Our ref: Raymond Avenue Multi-level Warehouse Matraville (SSD-31552370)

26 July 2022

Subject: Raymond Avenue Warehouse, Matraville (SSD-315523370) Request for Additional Information

DRAWING TITLE
PMF FLOOD LEVELS AND
DEPTHS-PRE DEVELOPMENT
DRAWING No C014452.00-F09
ISSUE A

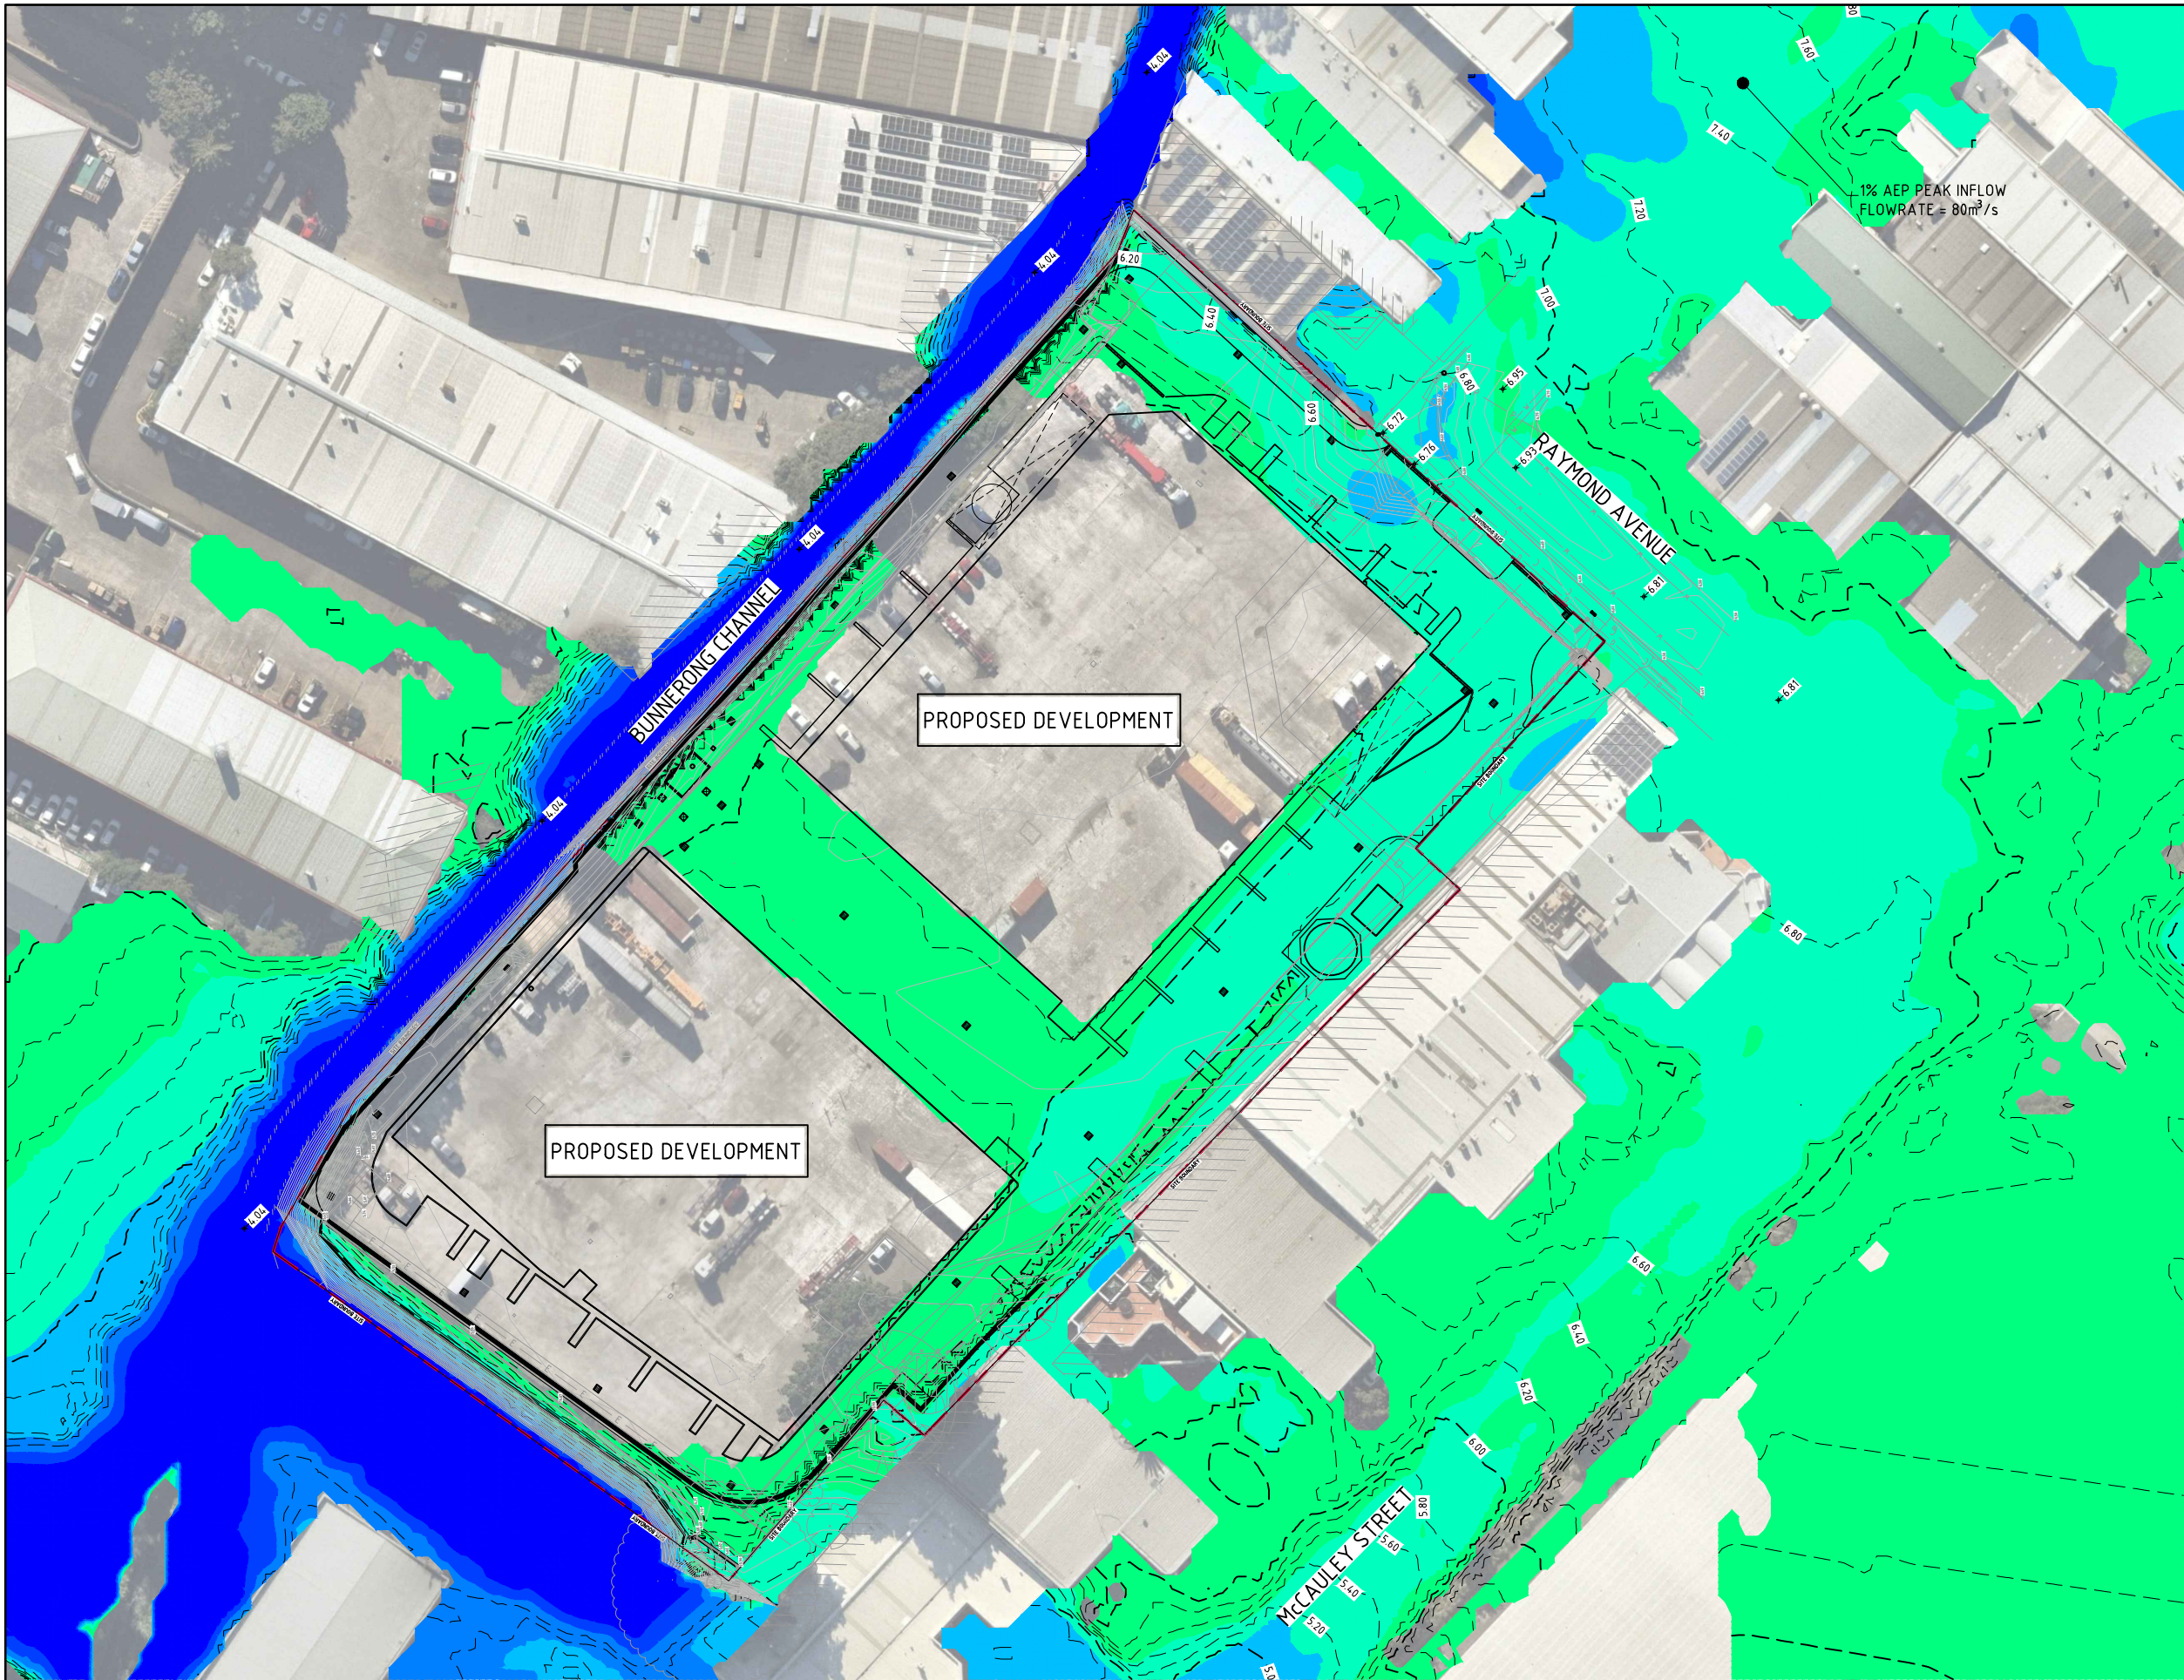
§ *The RTS Report notes that a Flood Risk Management Plan has been prepared as part of the updated Civil Engineering Report (Appendix R). Council's technical staff have reviewed the updated Civil Engineering report (Appendix R) and note that information regarding the risk management plan up to the PMF is not addressed. Council requires this information to be provided to ensure the flooding impact of the proposal is accurately addressed.*
